Our ref: DOC21/415995-18
Your ref: SSD-8706

Notice of Exhibition – Night Racing at Royal Randwick Racecourse (SSD-8706) (Randwick)

Thank you for your referral dated 26 May 2021 inviting comment from Heritage NSW on the proposed Night Racing at Royal Randwick Racecourse.

Figure 46 OEH AHIMS register of known sites

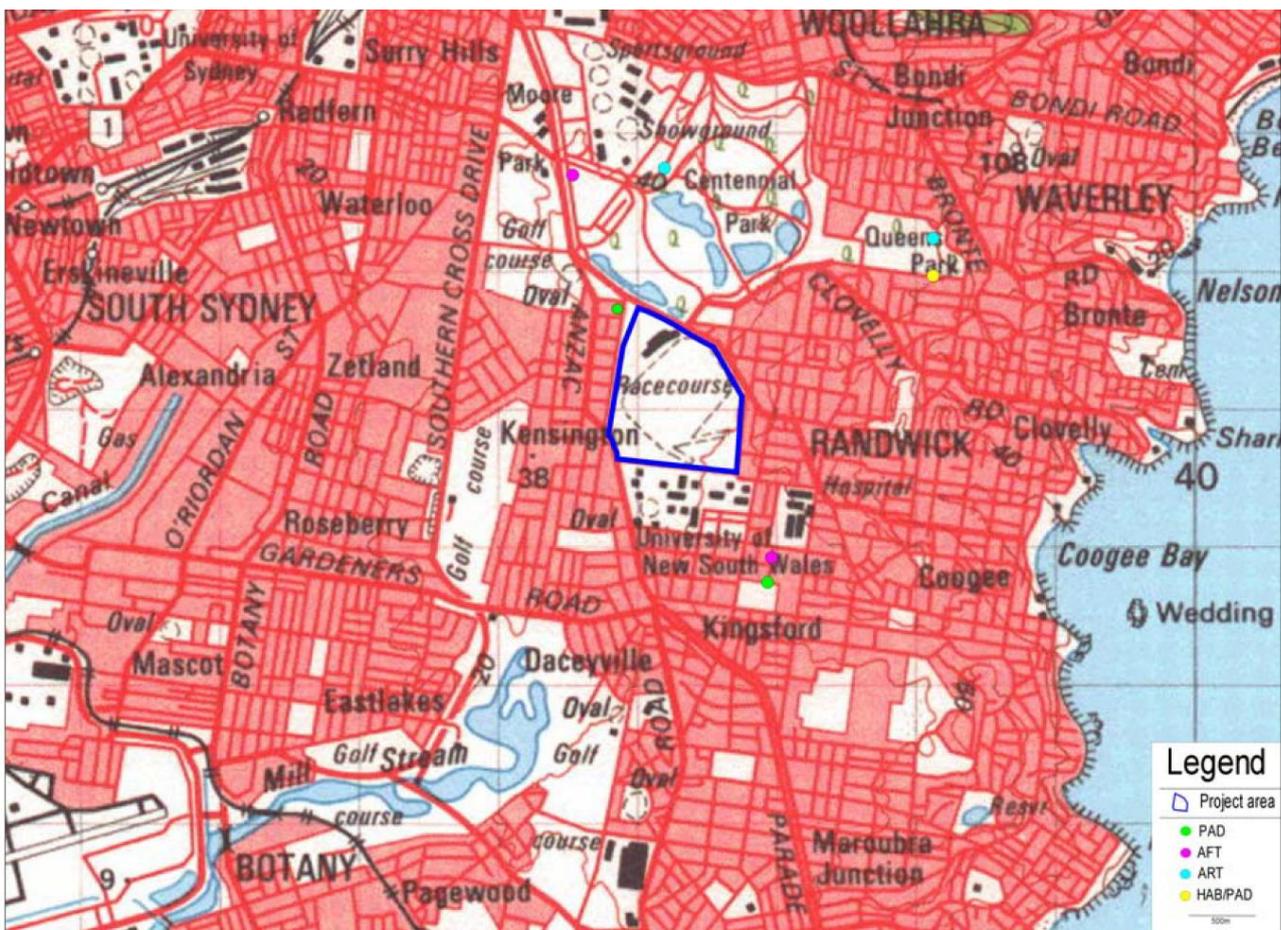
- An updated search of the Aboriginal Heritage Information Management System (AHIMS) database be undertaken as the previous search was undertaken on 13 October 2017 and the search results are only valid for 12 months.
- Section 2.2 of the report be updated because:
 - it currently references the Lake Macquarie area; and
 - numerous archaeological studies have been undertaken in the local Randwick area since 2017 which have identified significant sites and a natural sand body of

archaeological sensitivity immediately south of the racecourse. These sites and additional studies need to be considered.
